Nick Robertson  
6227 5<sup>th</sup> AVE NW  
Seattle, WA 98107.  
RE: 2009-003-SUB1- ZETTEL RESIDENCE  
6415 SE 24<sup>TH</sup> ST MERCER ISLAND 98040

Please see correction responses for **CORRECTION NOTICE #1- ORDINANCE/STRUCTURAL**

AVERAGE BUILDING ELEVATION CALCULATION

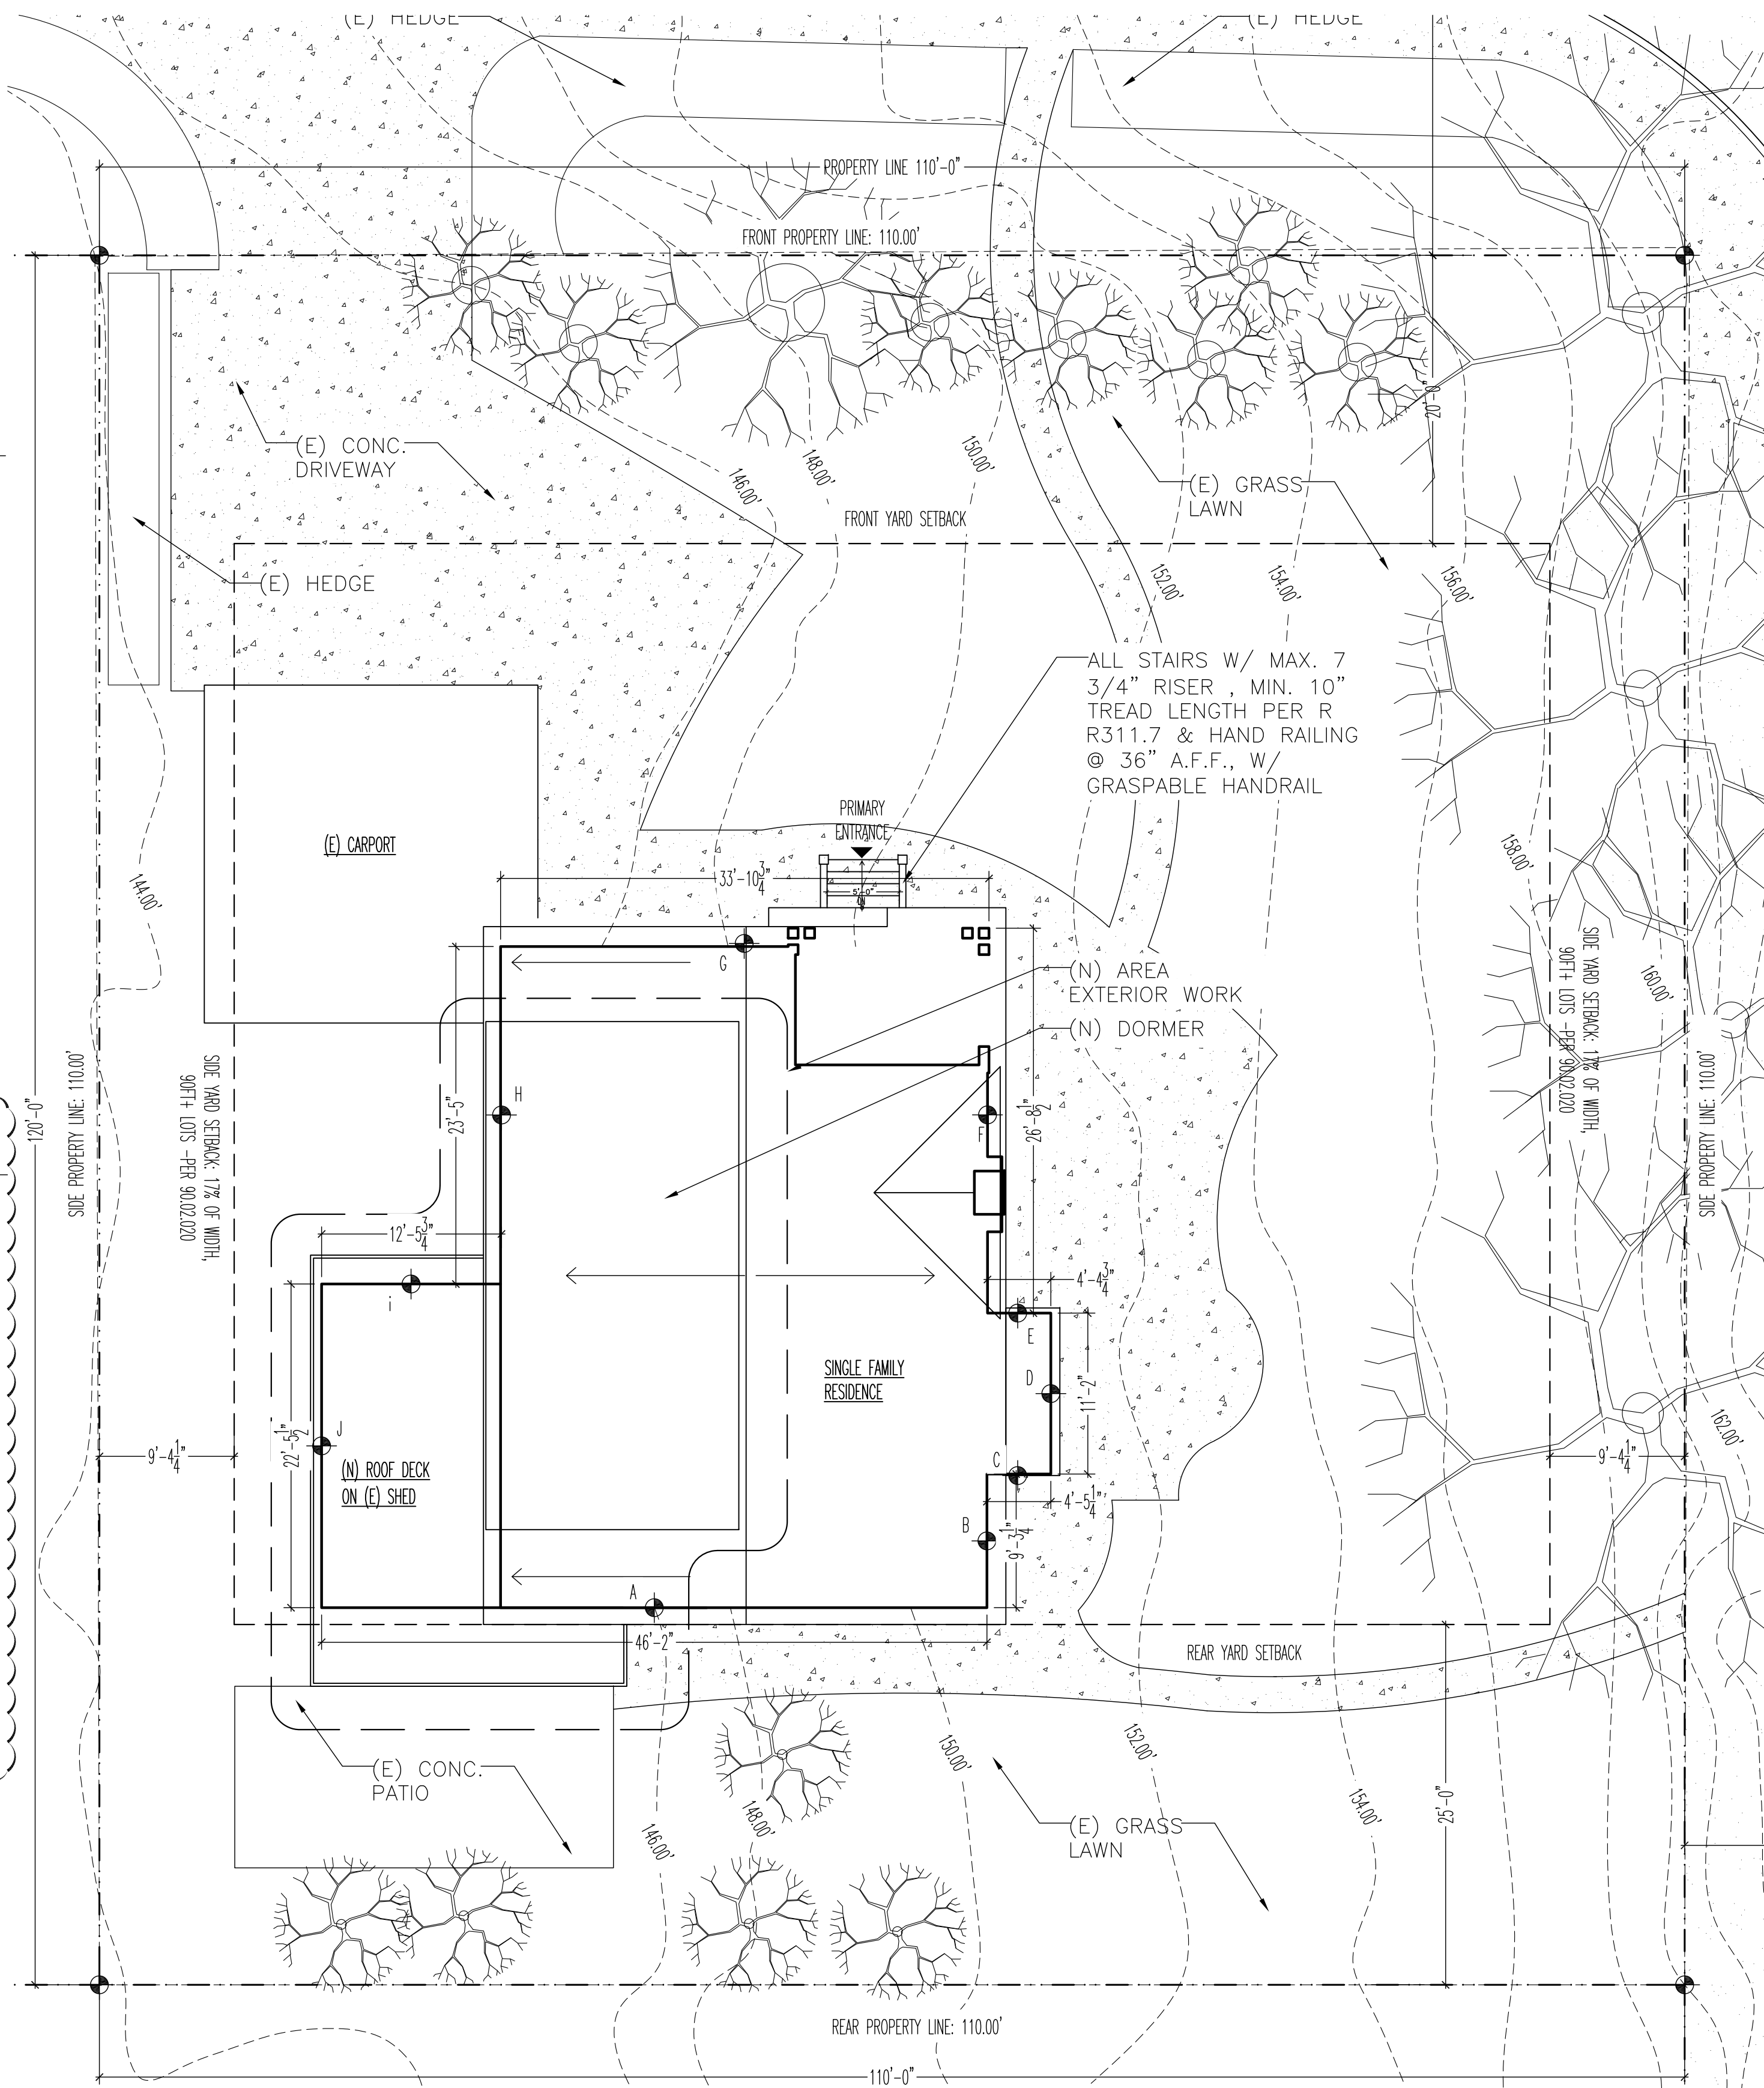
Author: PlanningReview (andrew.leon@mercergov.org) Subject: Comment Date: 10/29/2020 11:54:59 AM -07'00'  
Please provide calculations for the average building elevation.

Author: NICK ROBERTSON (NICK@STUDIOPIANONOBILE.COM) Subject: Date: 12/18/2020 6:05:42  
Sticky Note: average building elevation calculation has been added to sheet

PROPOSED MAIN FLOOR PLAN

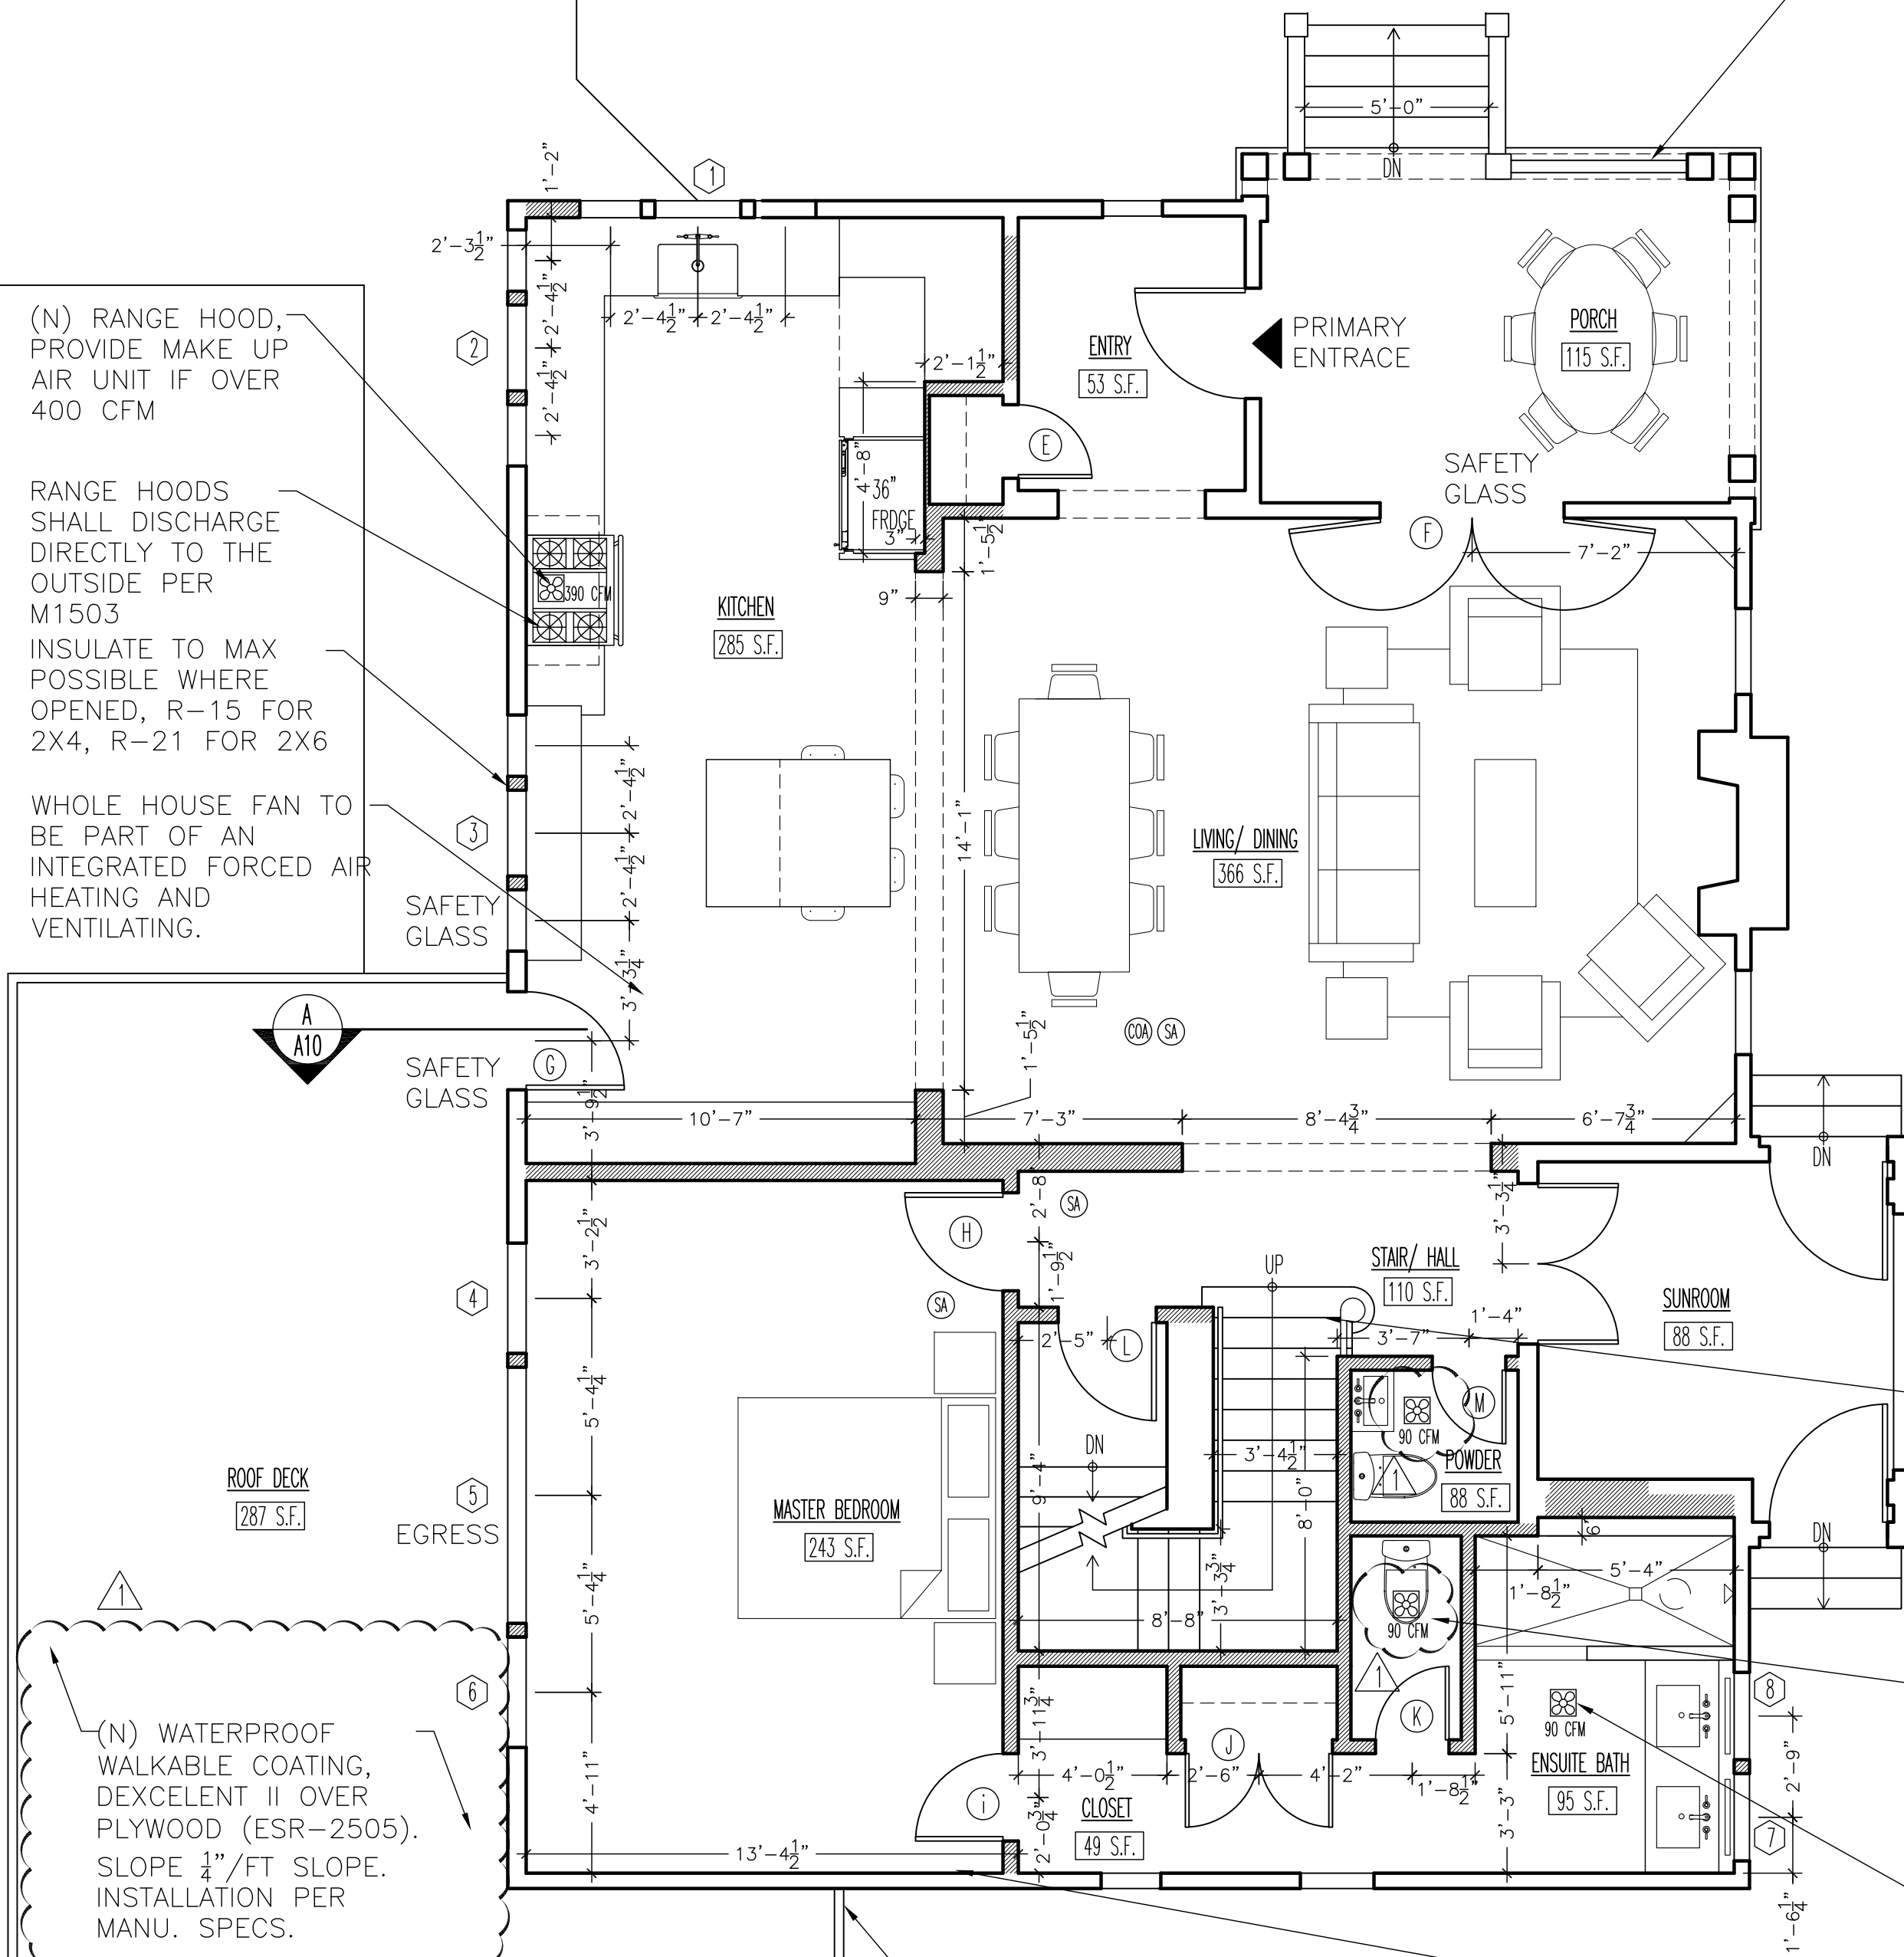
Author: Building Review (paul.skidmore@mercergov.org) Subject: Comment Date: 11/27/2020 6:52:10 PM  
The existing floor plan indicates existing construction to be demolished. Please remove demolished walls from proposed main floor plan or clearly delineate from existing to remain and new construction.

Author: Building Review (paul.skidmore@mercergov.org) Subject: Comment Date: 11/27/2020 8:29:43 PM  
Indicate minimum protection for accessible space under stairs. See IRC Section 302.7

Author: NICK ROBERTSON (NICK@STUDIOPIANONOBILE.COM) Subject: Date: 12/11/2020 4:59:53 PM  
Sticky Note: overlaid demo plan has been deleted

Author: NICK ROBERTSON (NICK@STUDIOPIANONOBILE.COM) Subject: Date: 12/11/2020 4:32:18 PM  
Sticky Note: note has been added to revised plans

PROPOSED ROOF
PLAN

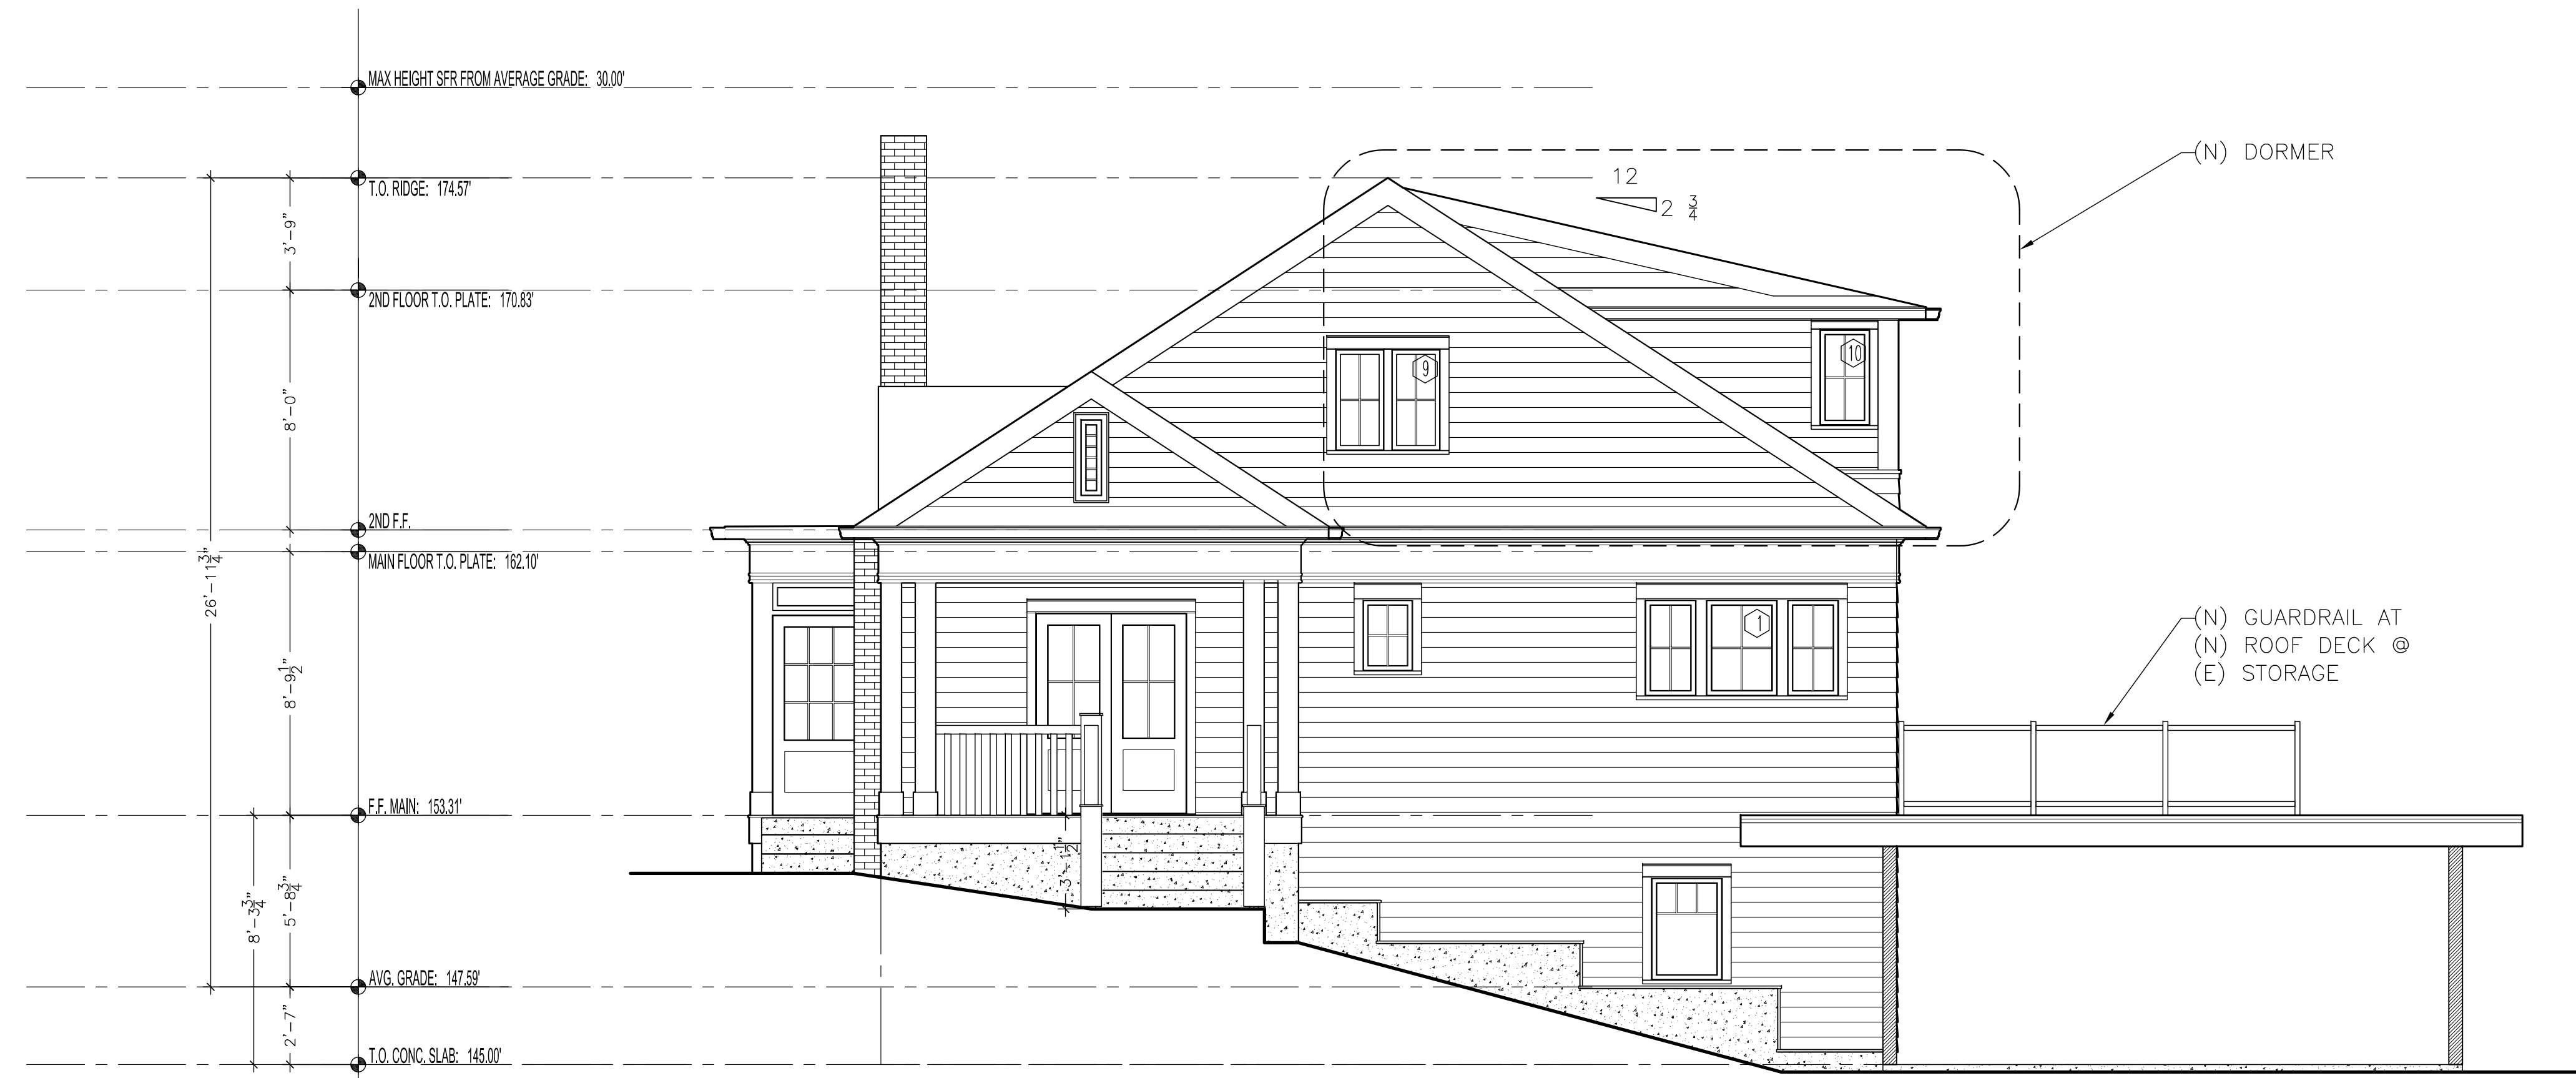
Please indicate construction of roof deck. Note all materials. Show how insulative requirements and cross-ventilation requirements are met. Provide verification that the manufacturer of the roof membrane / protection approved for use as a walking deck per the International Code Council Evaluation Service (ICC-ES) *Roof and Walking Deck Membranes* in accordance with the ICC-ES Criteria for Walking decks (AC39).

Author: NICK ROBERTSON (NICK@STUDIOPIANONOBILE.COM) Subject: Date: 12/17/2020 2:46:11 PM  
Sticky Note: unheated storage under deck, exposed joists from inside. Detail added to sheet A5, showing Dexcelent II as proposed product complying with ESR-2505
